ATTACHMENT 4

Email Advice from Bega Valley Shire Council

From: Newton, Peter
Sent: Friday, 16 April 2010 12:48 PM
To: 'jarmstrong@secc.com.au'
Cc: 'mark.schofield@planning.nsw.gov.au'
Subject: MP 06-0147 Ivor Jones Drive Wonboyn

DRAWING TITLE		
PLAN & LONGITUDINAL SECTION OF ACCESS ROAD CH 00 - CH 360		
Project No. 07000168	Drawing No. 02	REV A

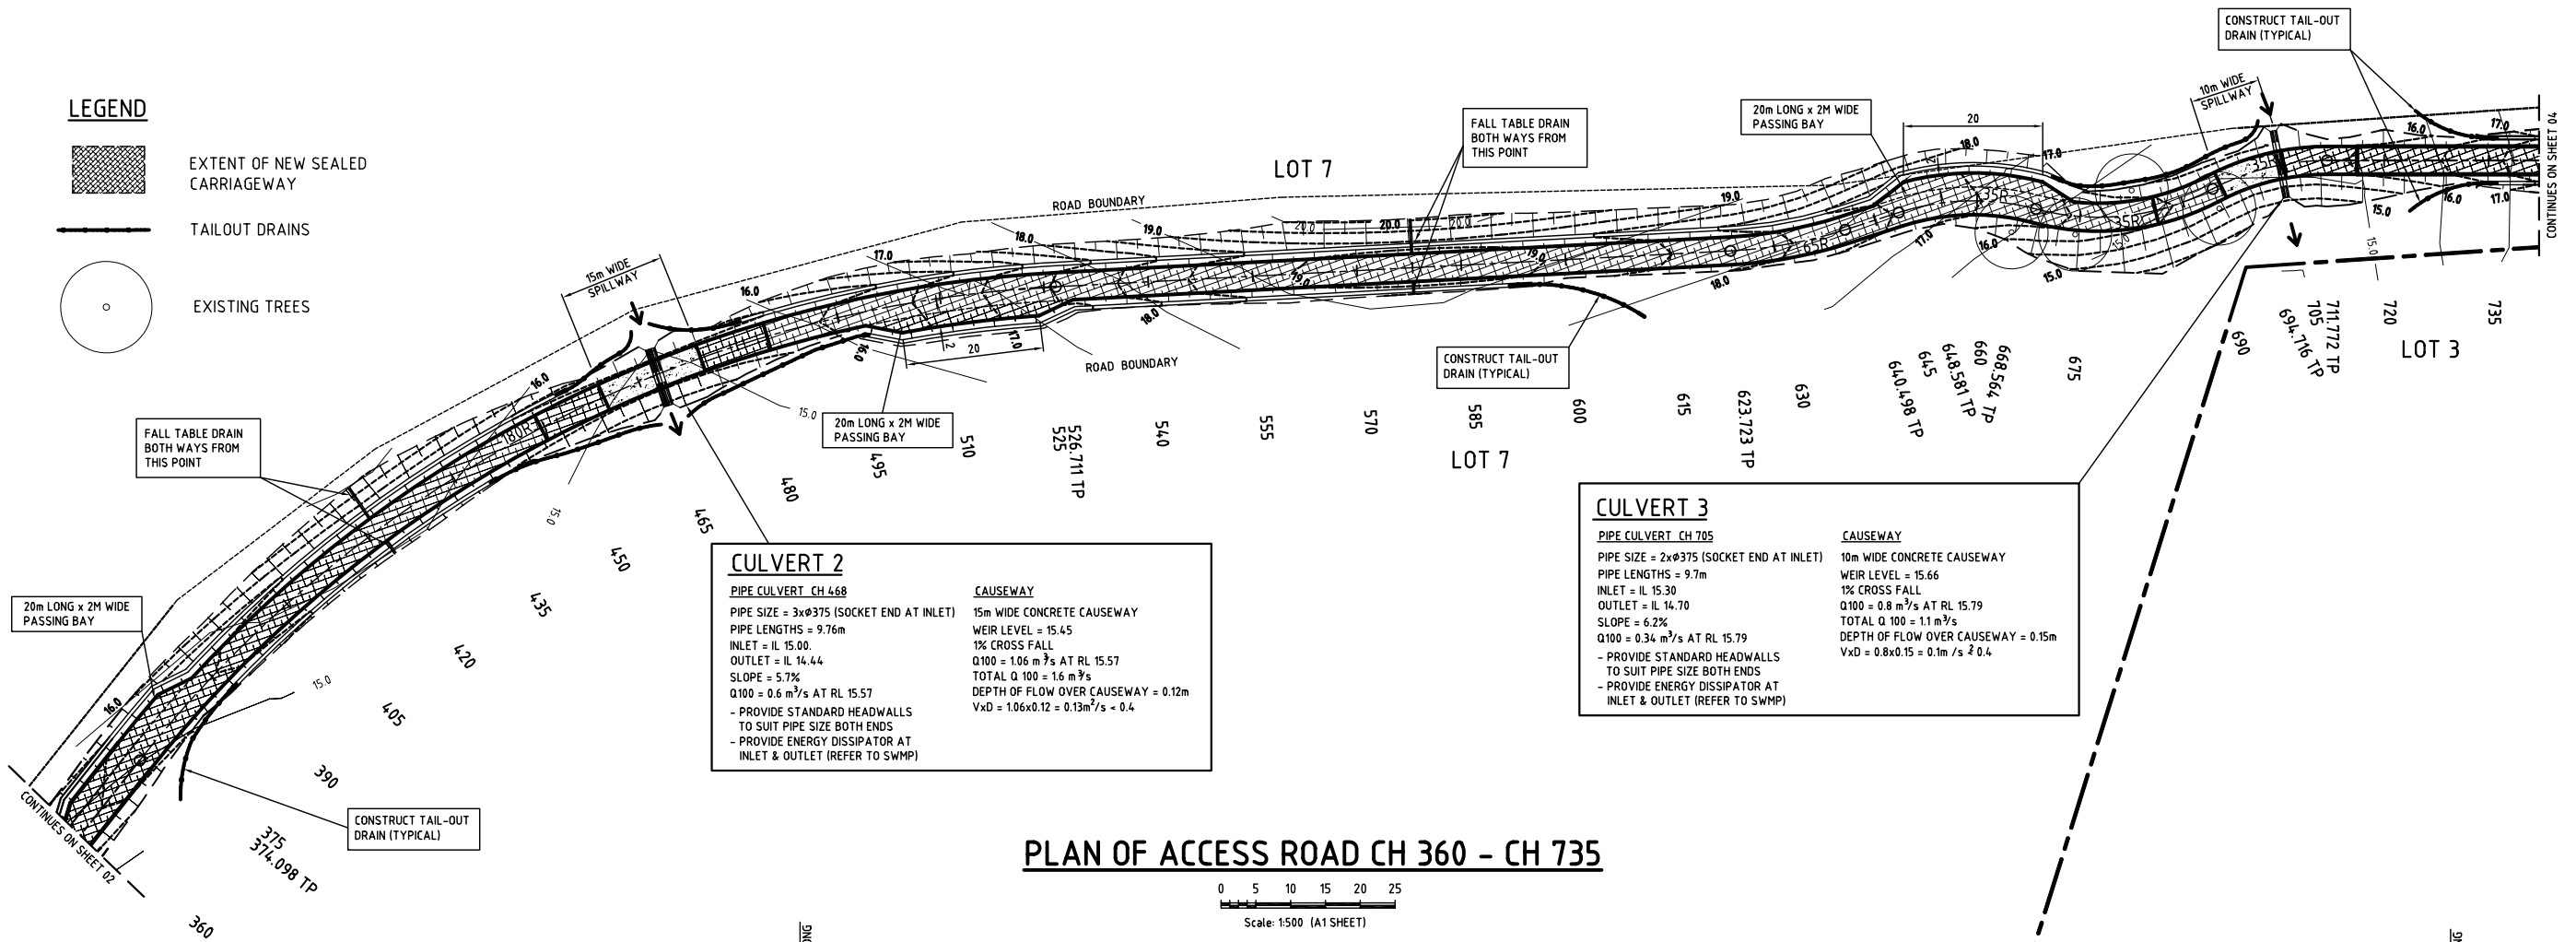
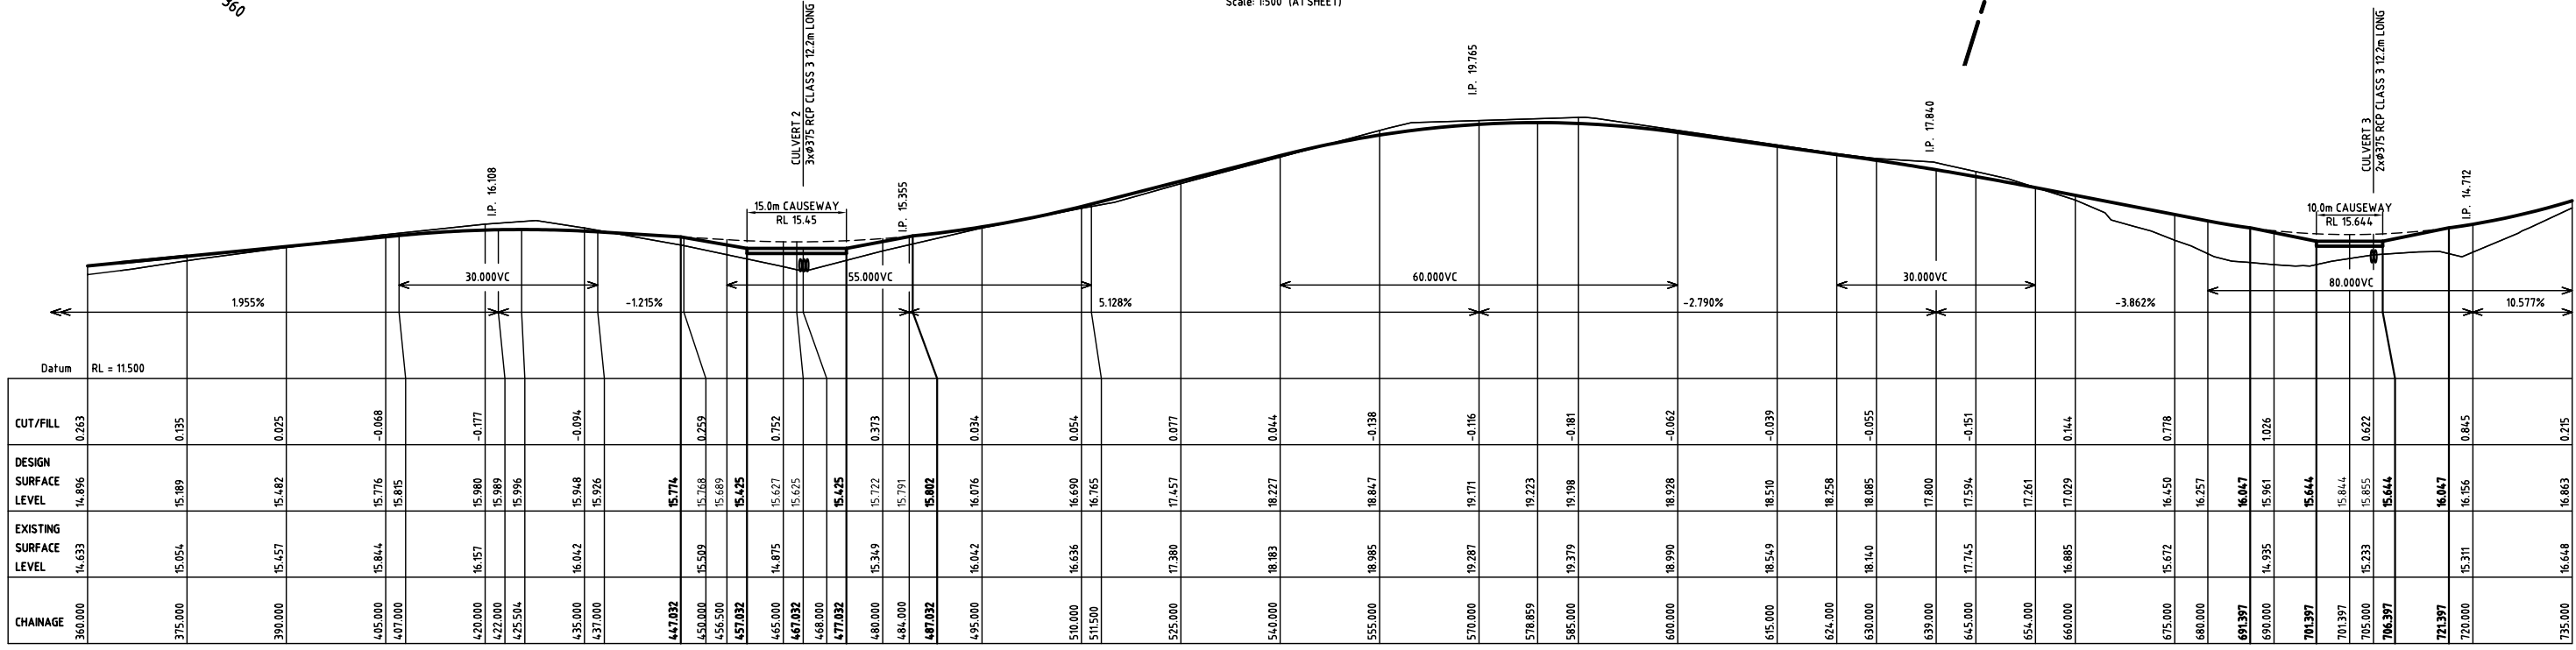
Further to our discussions regarding the above matter, the design as proposed (and attached) would be acceptable to Council with the provision of the 4.0 metre wide bitumen sealing to be extended to 20 metres past the access to the last proposed lot. This of course includes the proposed passing bays as nominated.

This access shall be contained within a 20 metre wide right of access within the residue lot. This will enable any future upgrades of the access to be dealt with through the one owner being the residue owner.

RFS however may require something greater than proposed in both the bitumen and gravel sections.
